Submission ID: 29036

We have some concerns over access to a river gauging station during the works at Uckington.

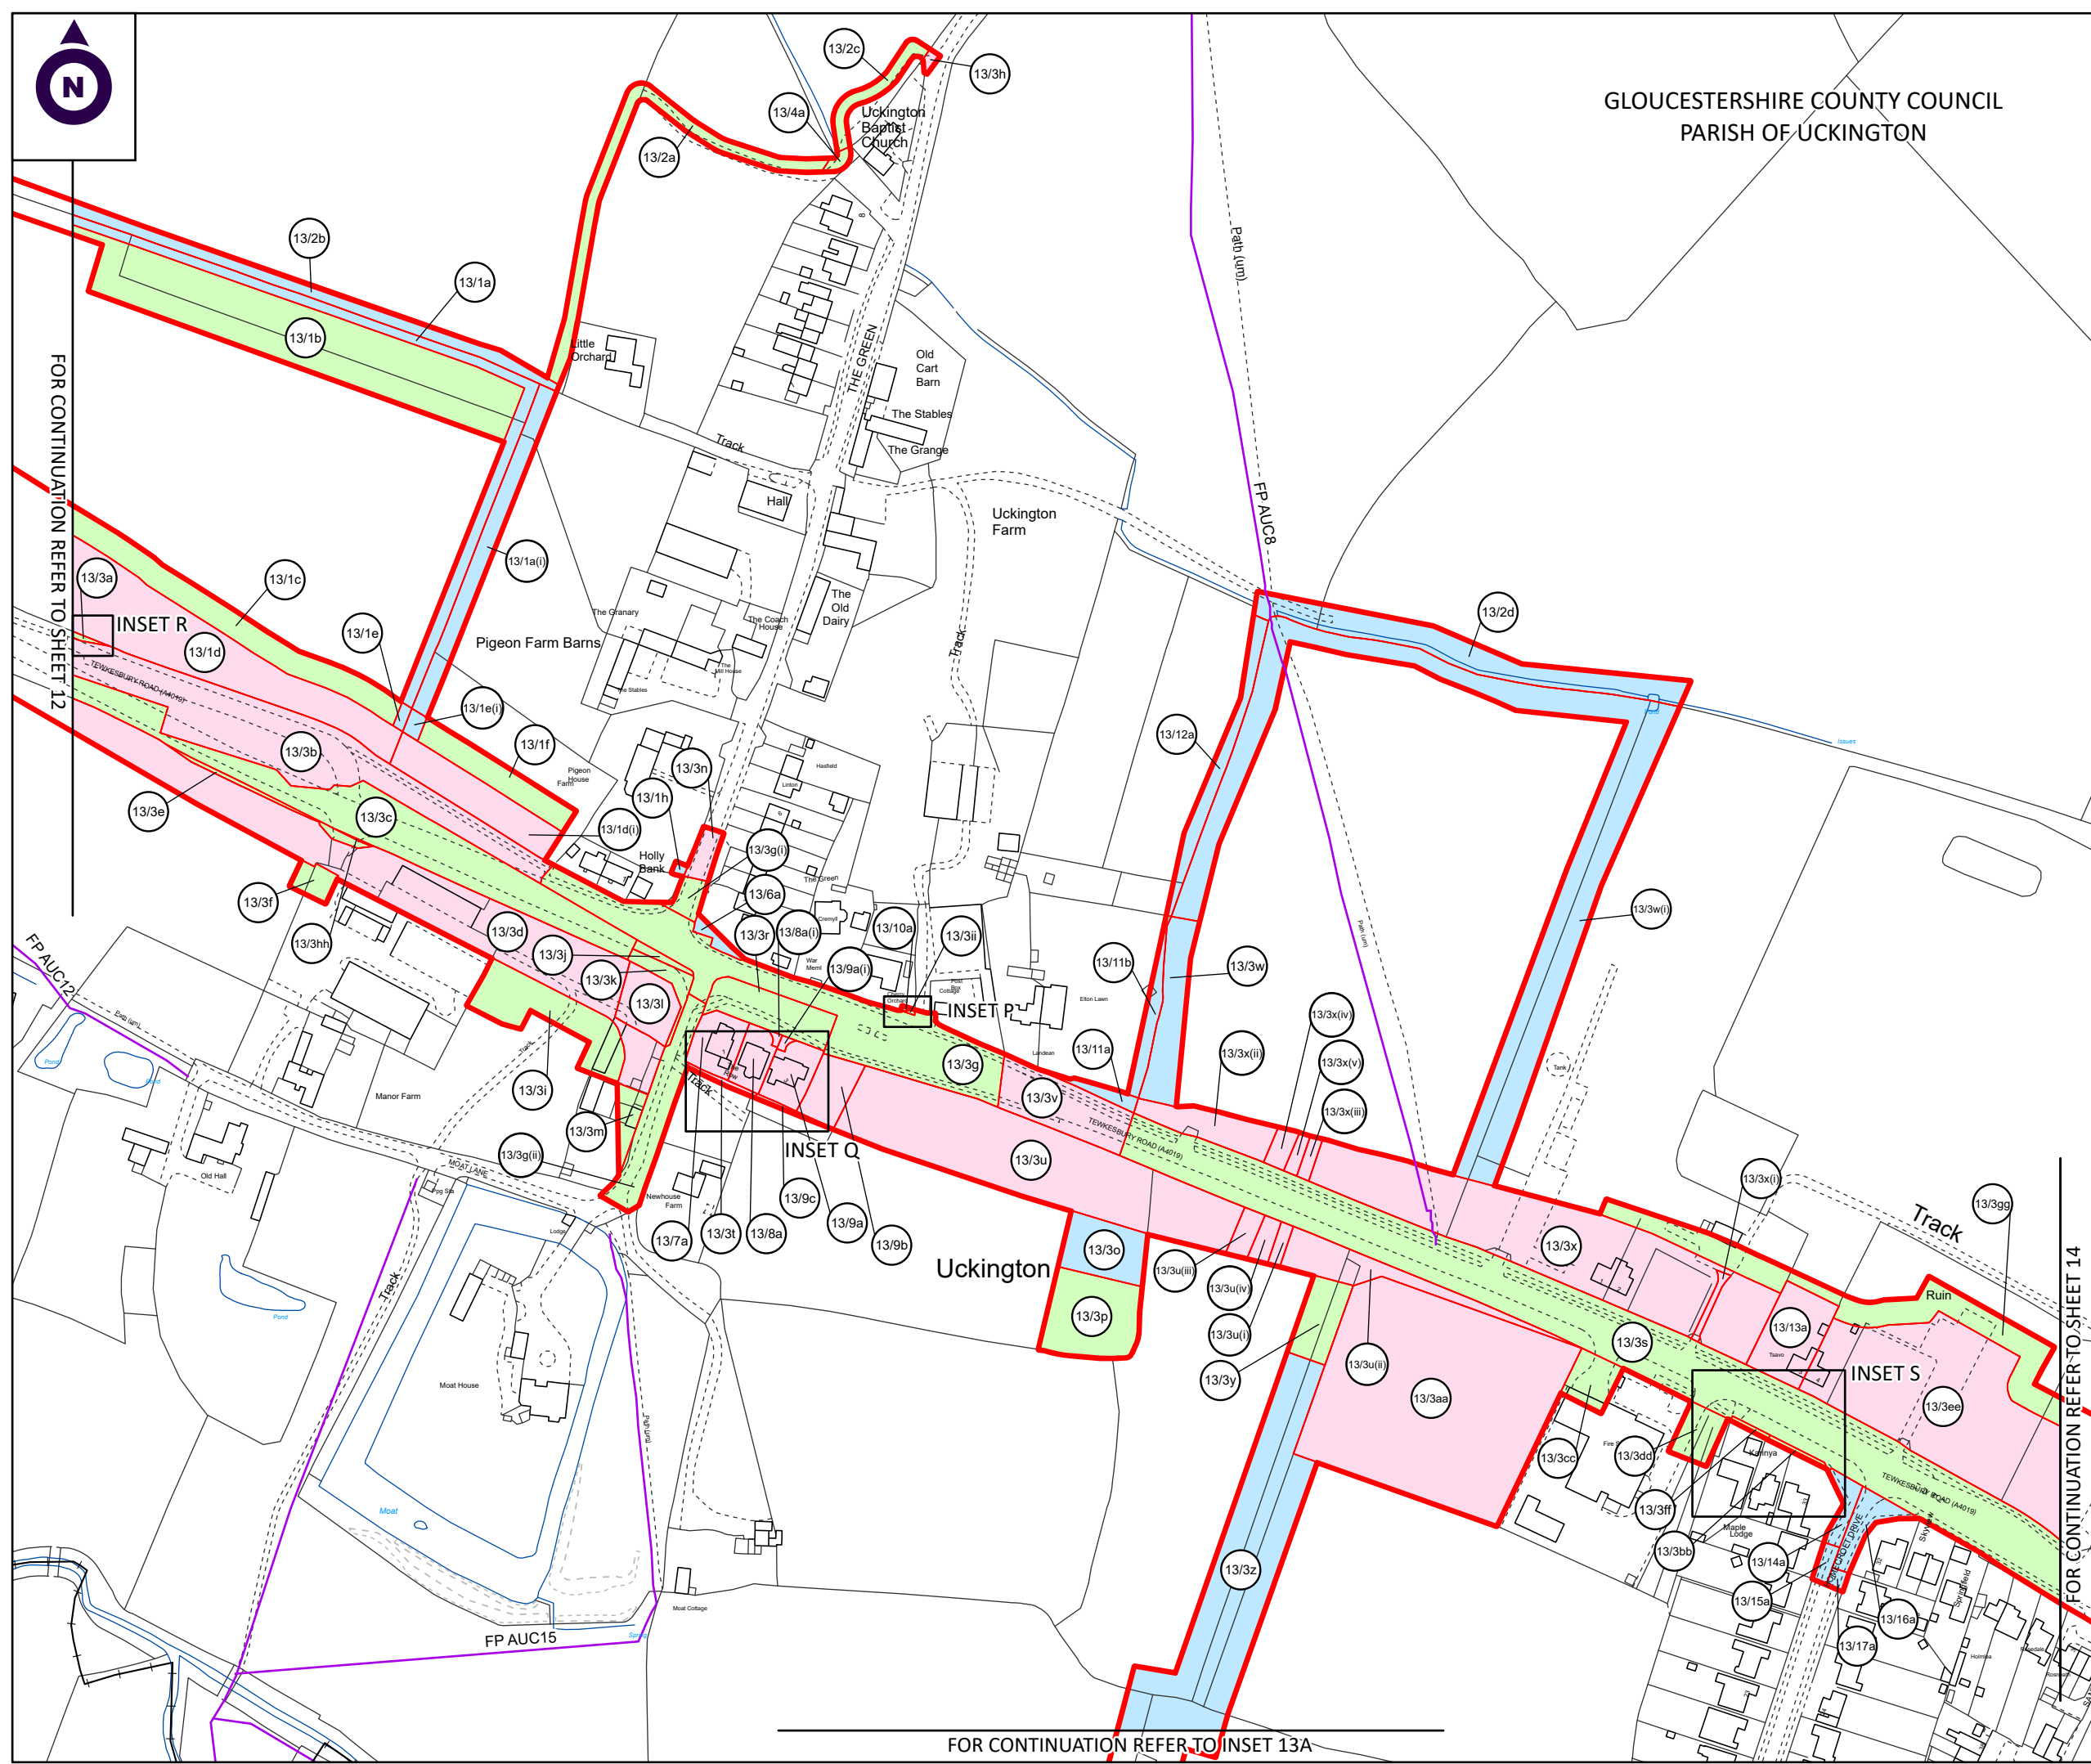
If I refer you to Sheet 13 of 16 (TR010063-000742-TR010063\_2.2\_Land\_Plans), we would normally use the A 4019, Moat Lane and then a track to access our asset (please see EAAAssetUckingtonPlan.pdf), however it looks as if the works will prevent this access.

We are not accessing this asset frequently, however, therefore if we could be provided with the dates of works, then our team believe we would be able to work around this.
